EPC STORMWATER REVIEW COMMENTS IN ORANGE BOXES WITH BLACK TEXT

The Shire At Old Ranch
Howells & Old Ranch Road
Colorado Springs, CO

EC-1
 Erosion Control Plan

EC-2
Erosion Control Details

**SG 1**

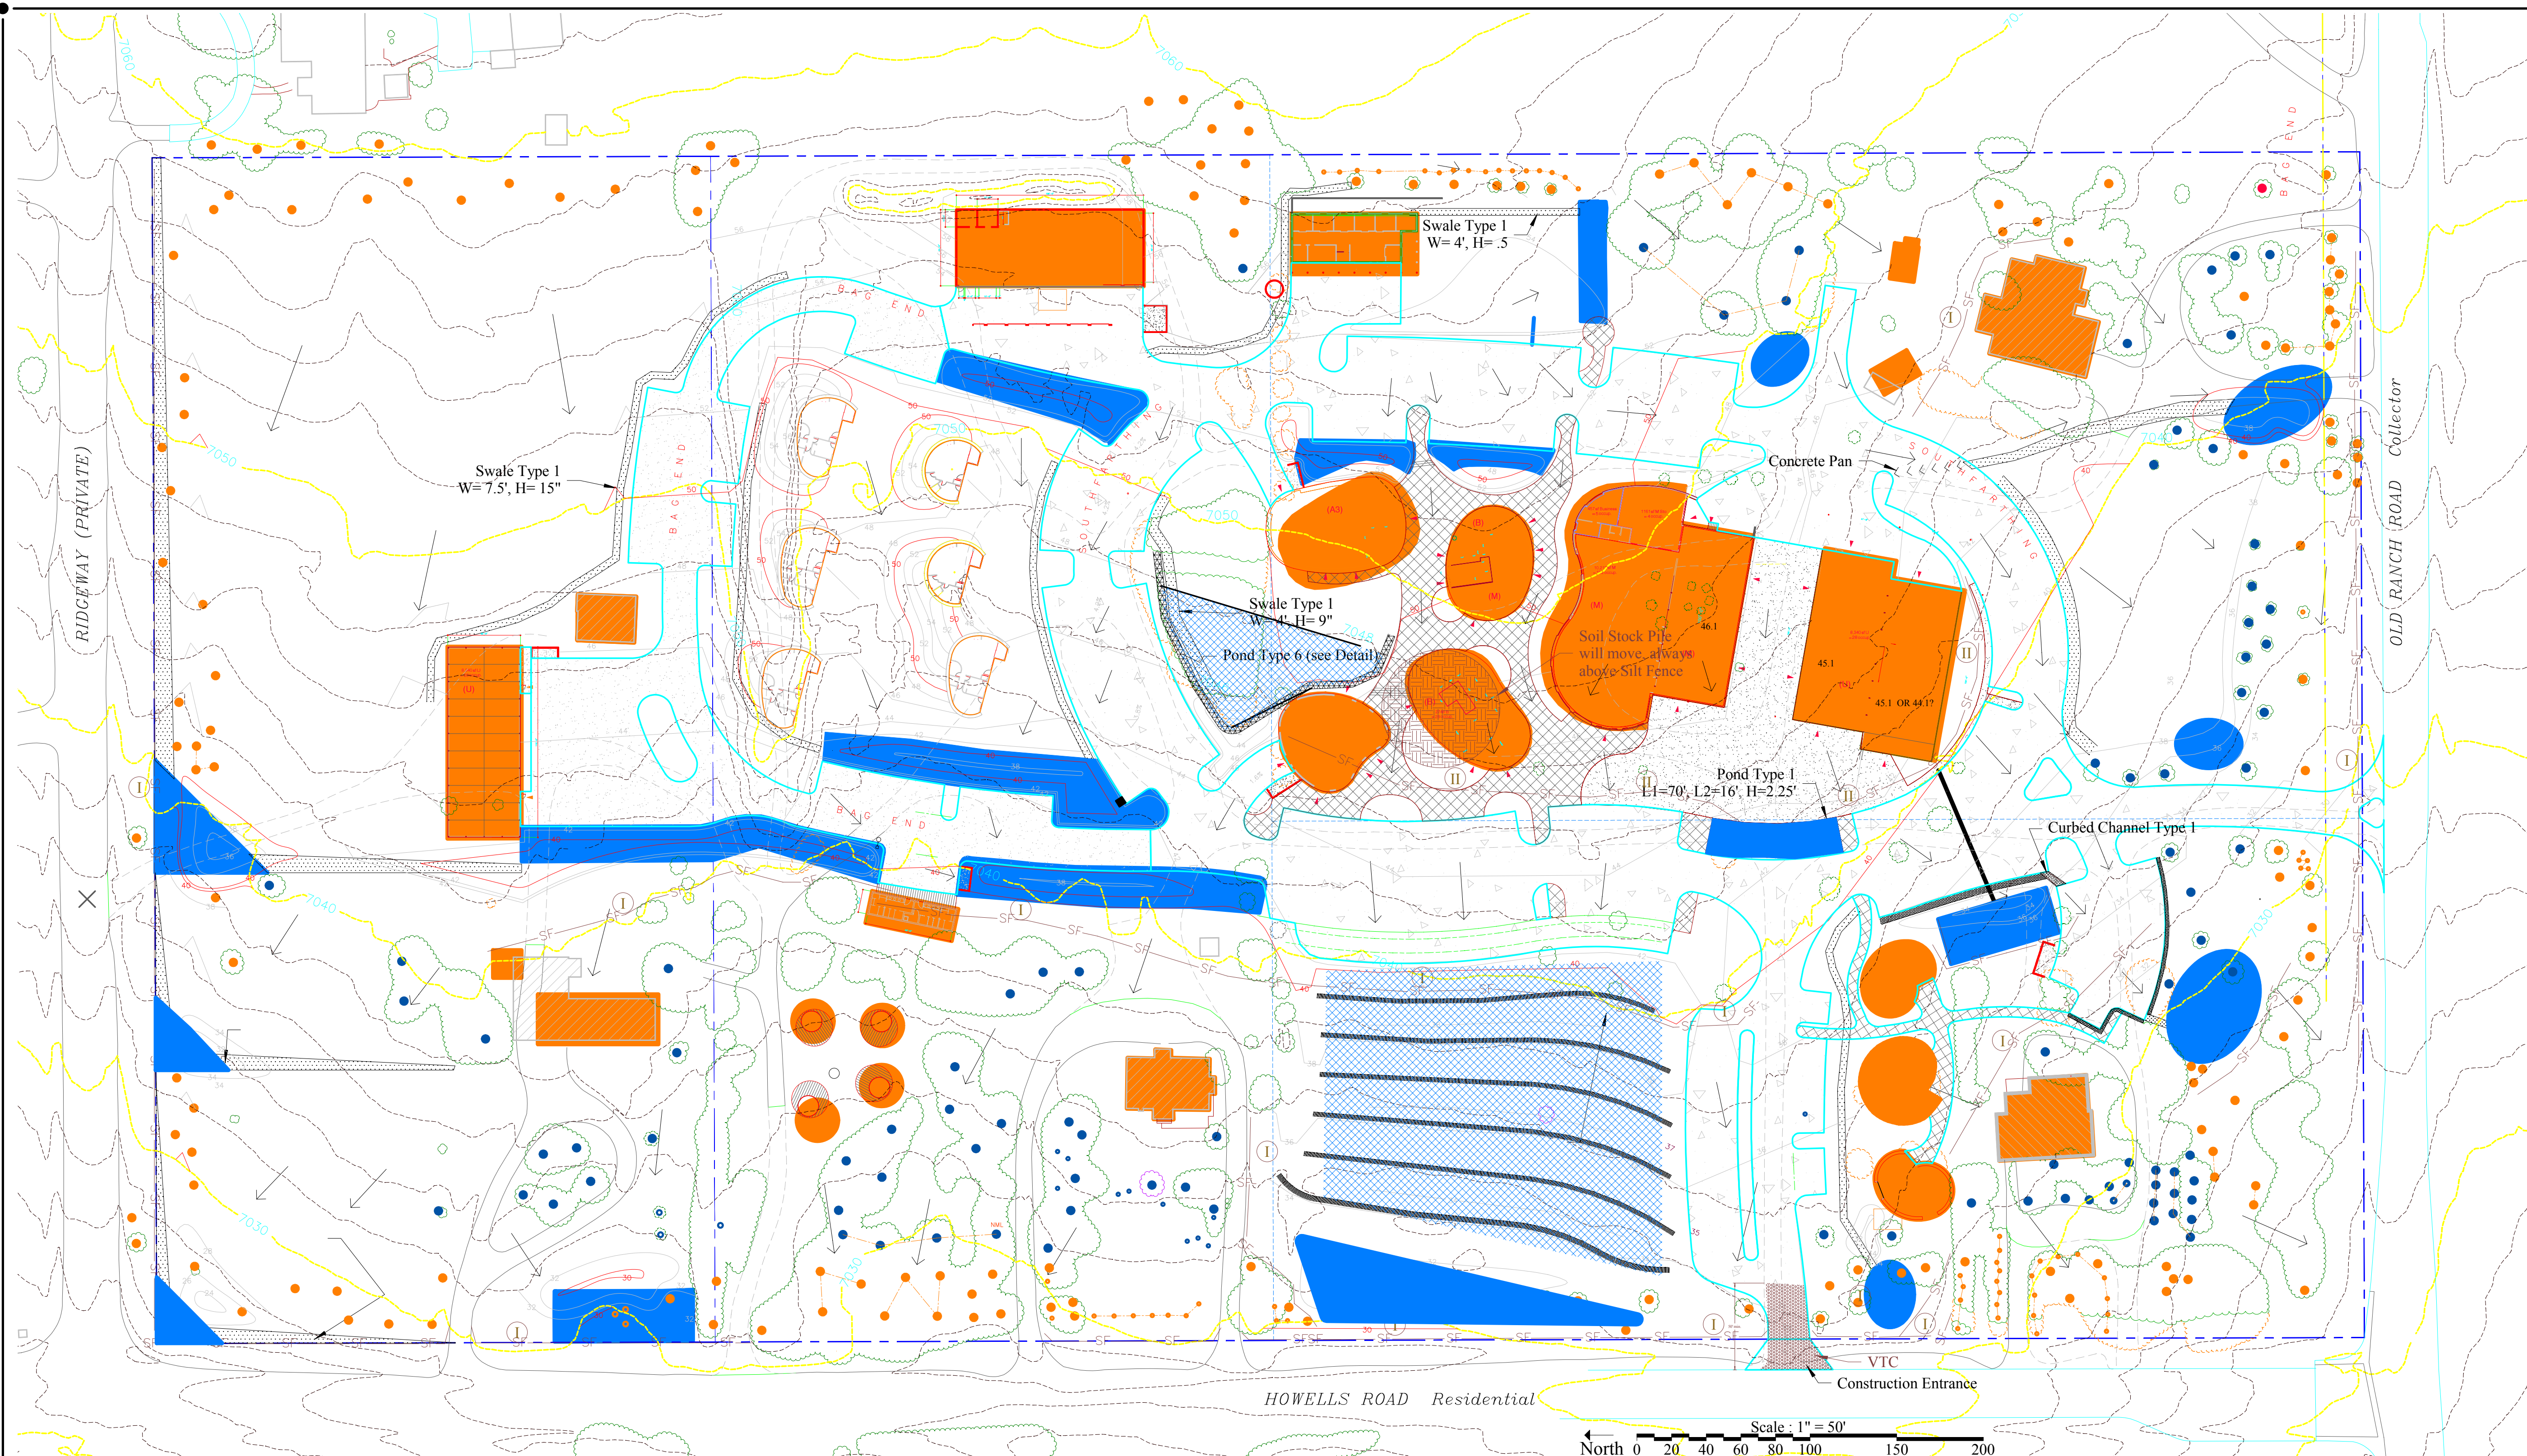
Identify the slope at this driveway, max 4% per ECM 2.4

please include land disturbance/construction to be done on Howells Road and Old Ranch road.

Contact the City of Colorado Springs regarding their requirements for this access

**Vehicle Tracking Control Pad - VTC**

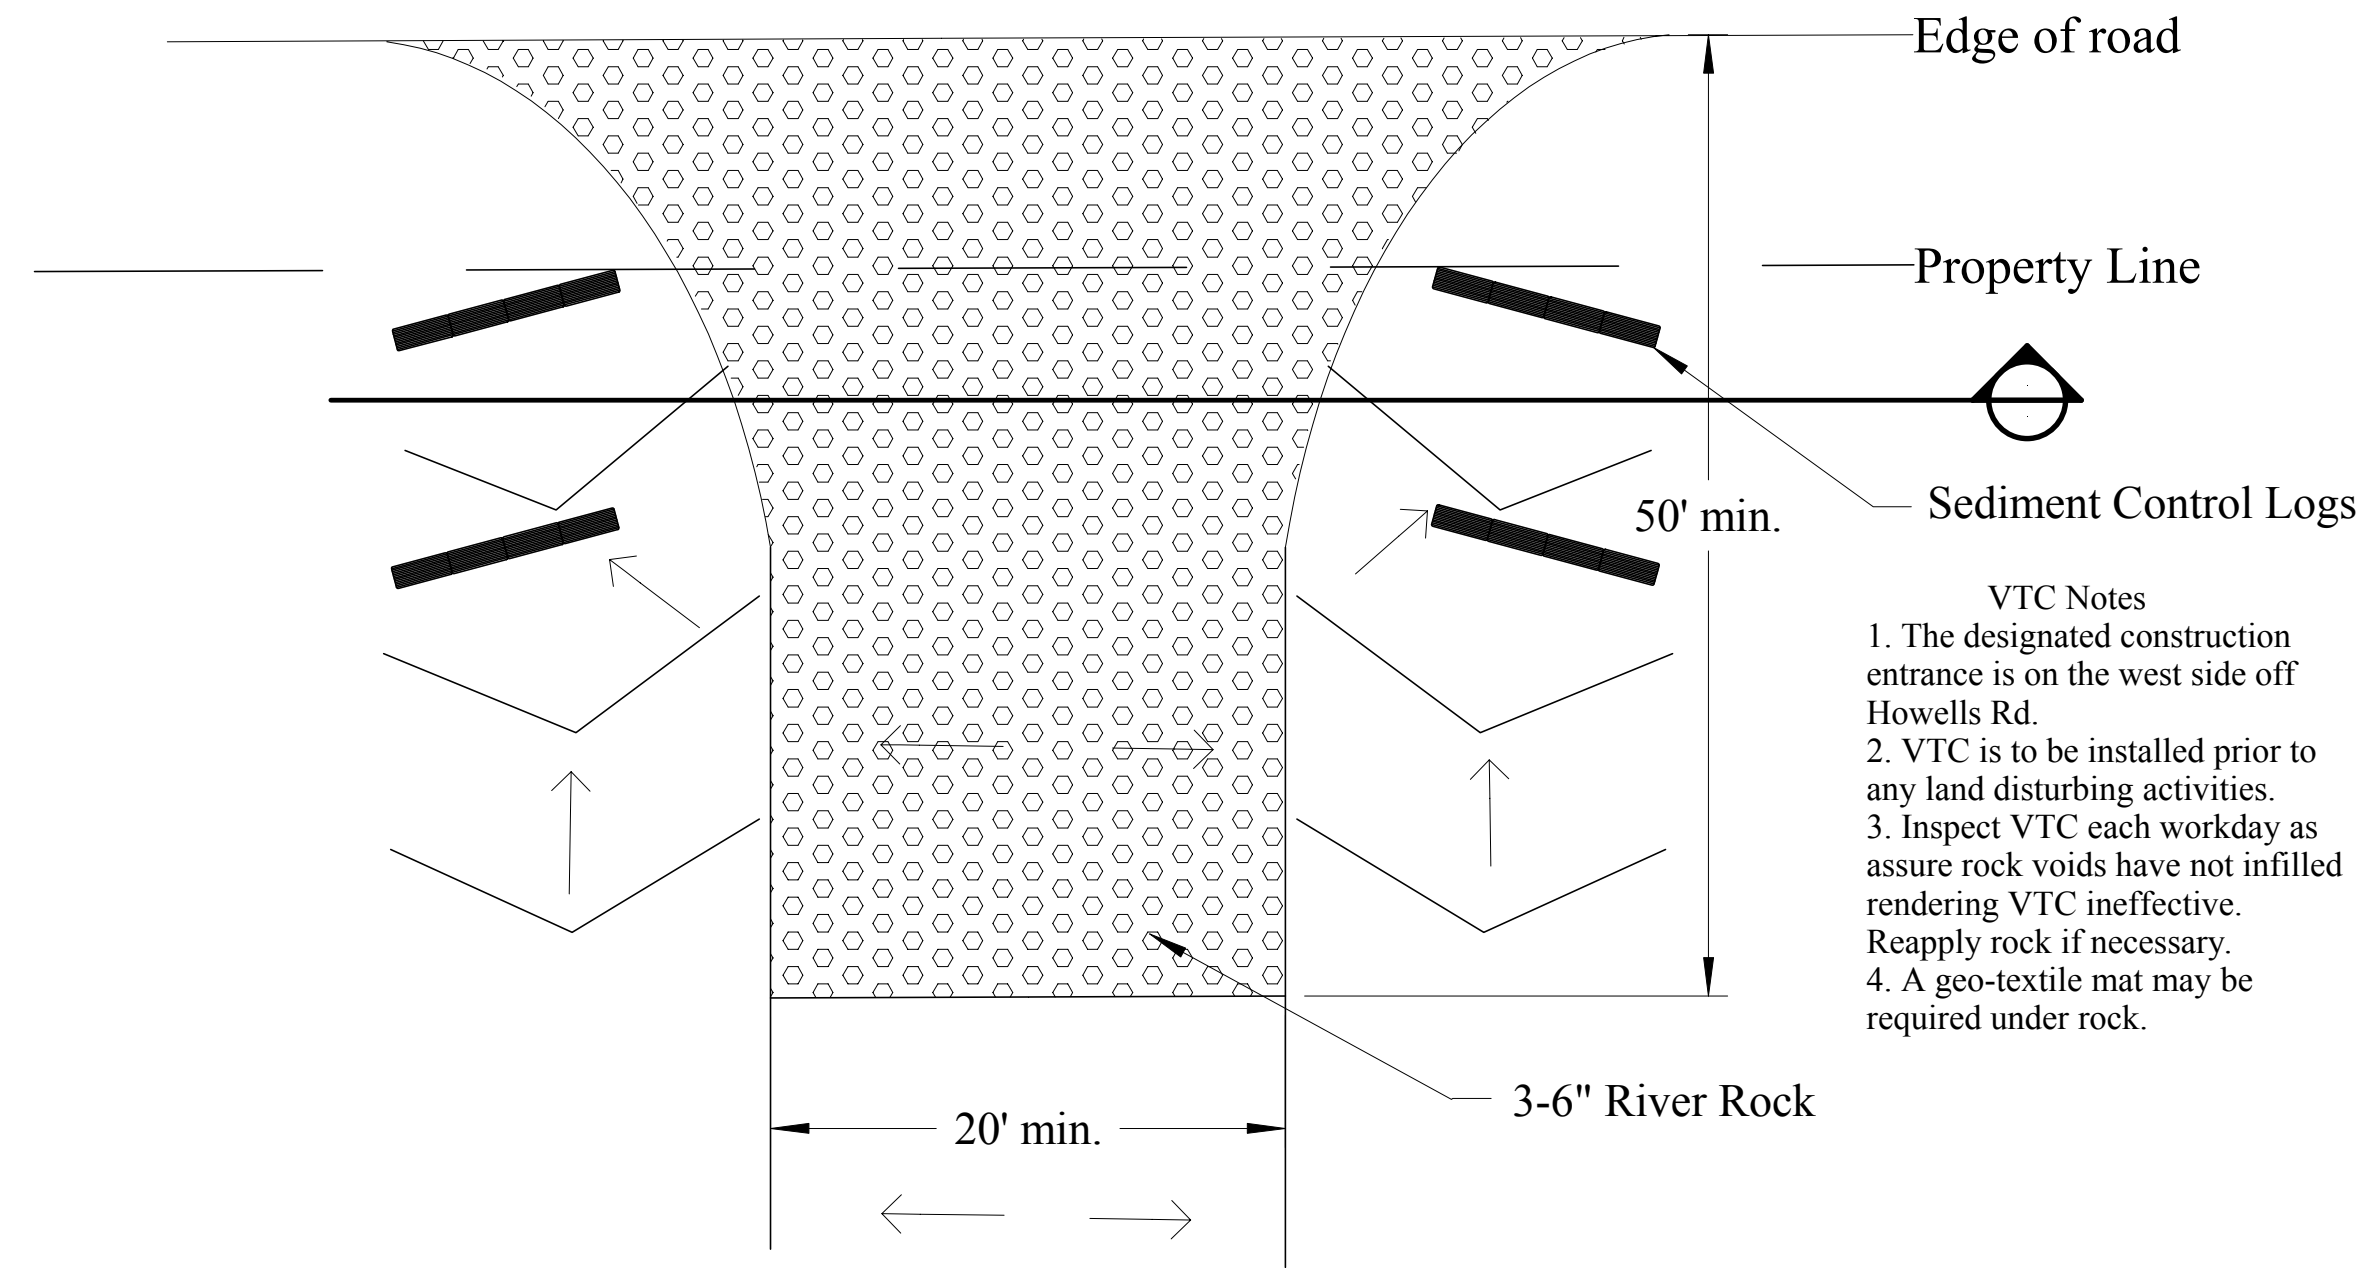
VTC Detail: Replace with EPC approved VTC detail (VT-1 and VT-2 in DCMV2, Chap 3.3) or revise to be 75ft min length.
